Our Ref: FP/99/18/HH
Your Ref:

Town & Country Planning Act 1990 (as amended)
Town & country Planning (Development Management Procedure) (England) Order 2015
Application for Planning Permission for Works or Extension to a Dwelling

Development Retention of timber outbuilding/shed to front garden
Location 50 Crossbush Road Felpham

| FLOOR PLAN & ELEVATIONS                                                                                   |                              |

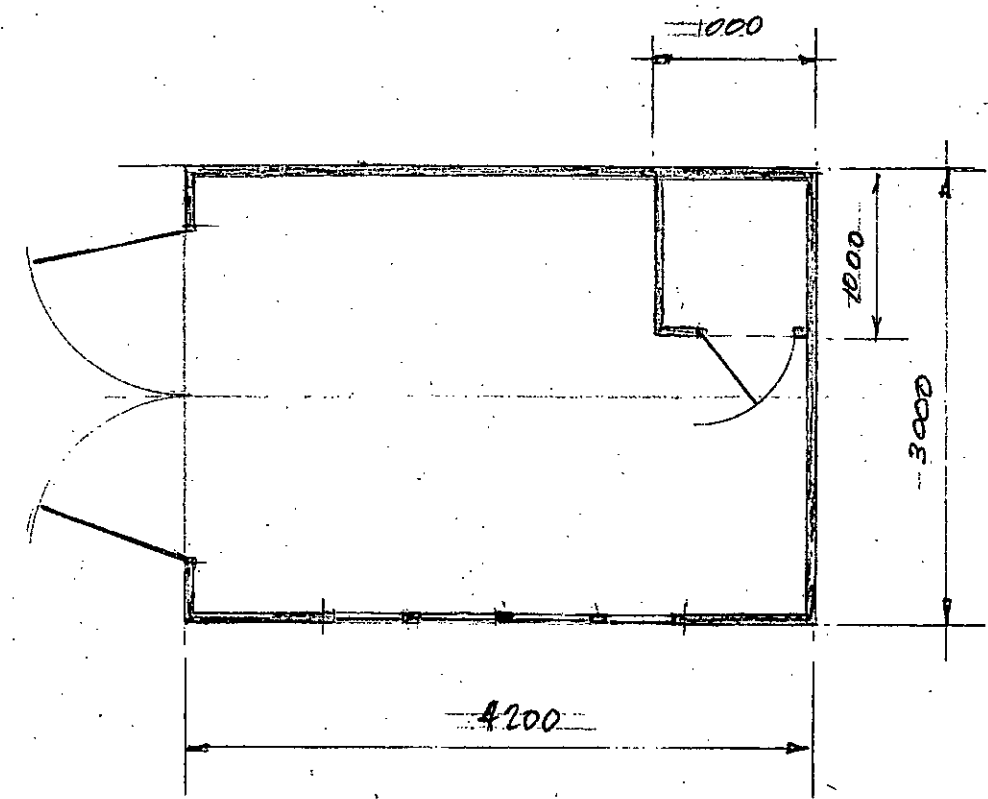
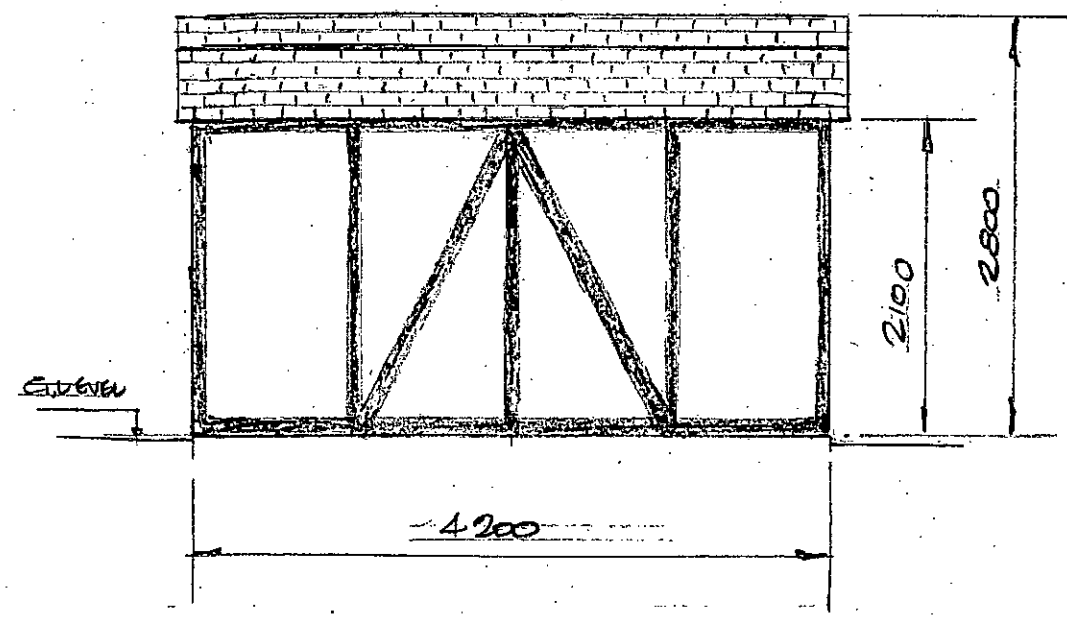
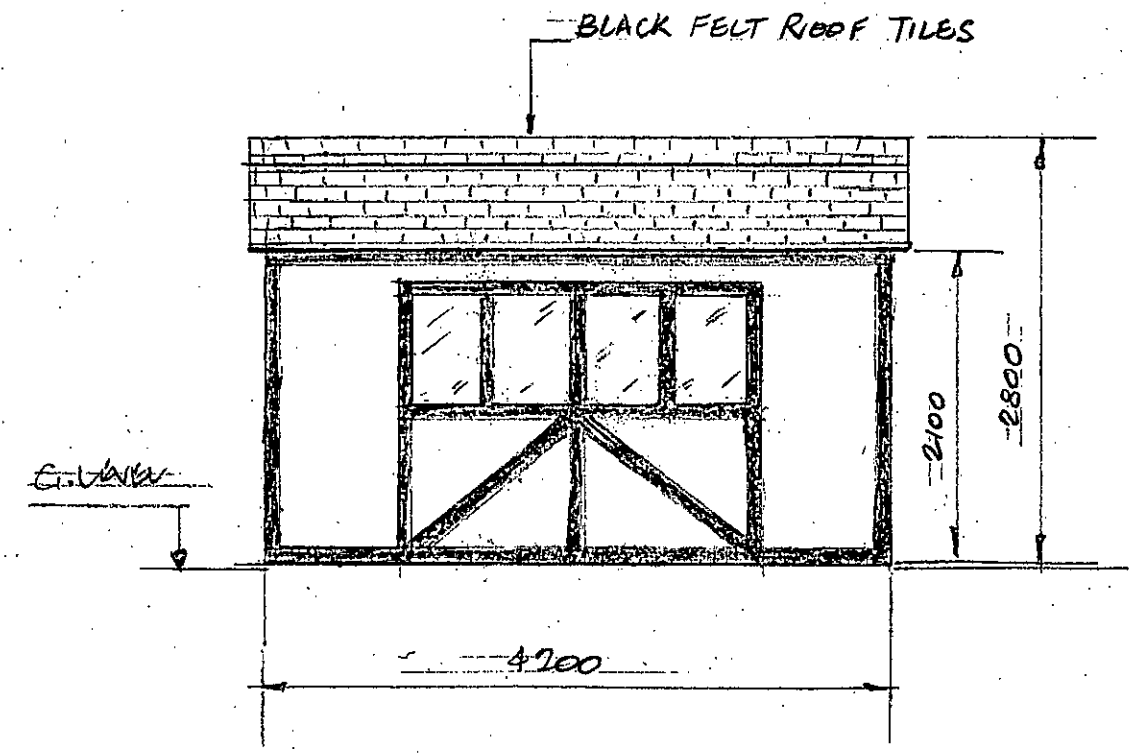
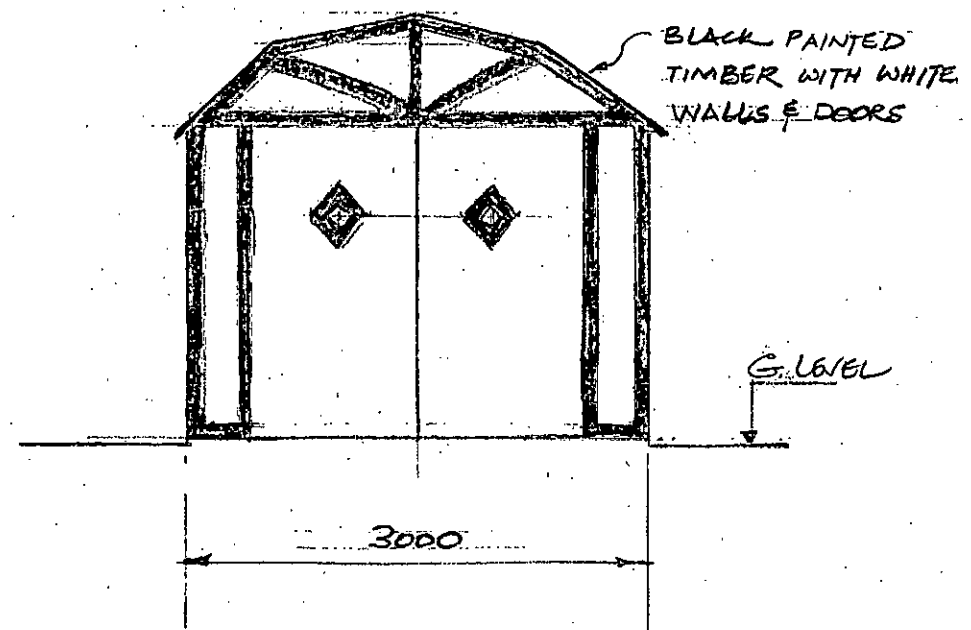
Floor Plans

Please submit 1 electronic or 3 paper copies of clearly labelled existing and proposed floor plans at a scale of 1:50 or 1:100. Further details can be found in the National Validation Requirements.

Please provide the other proposed side elevation.

Block Plan
Scale 1:500

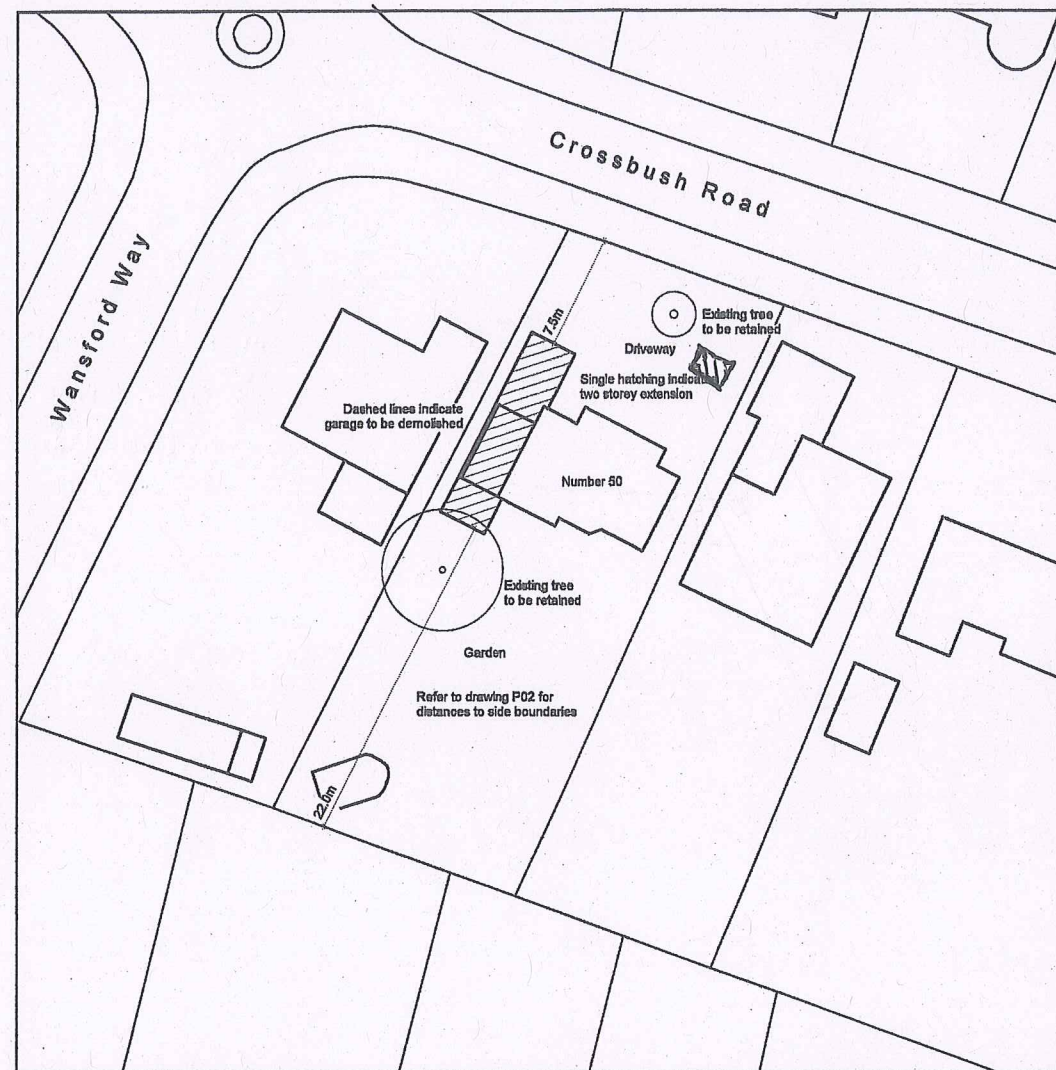
Block Plan Amend

Please submit 1 electronic or 3 paper copies of a block/site plan at a scale of 1:500 or 1:200. Further details of what must be included on the plan can be found in the National Validation Requirements. Please provide measurements from the proposal to the site boundaries.

Location Plan
Scale 1:1250

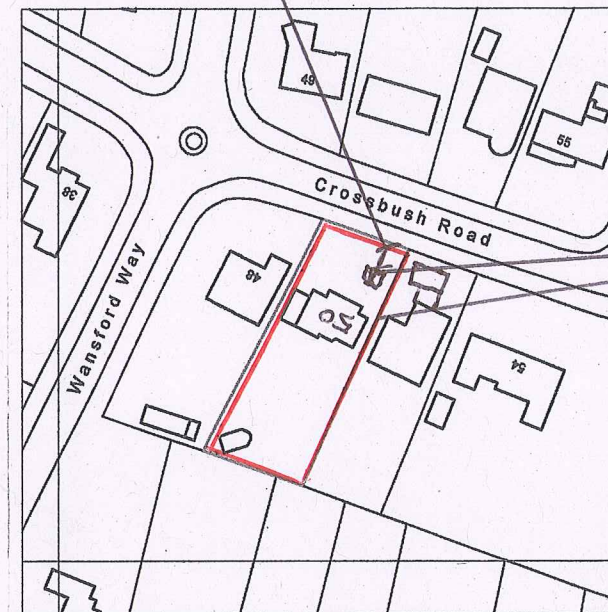
Location Plan

Please submit 1 electronic or 3 paper copies of a location plan at a scale of 1:1250 or 1:2500 for rural areas. Further details of what must be included on the plan can be found in the National Validation Requirements.
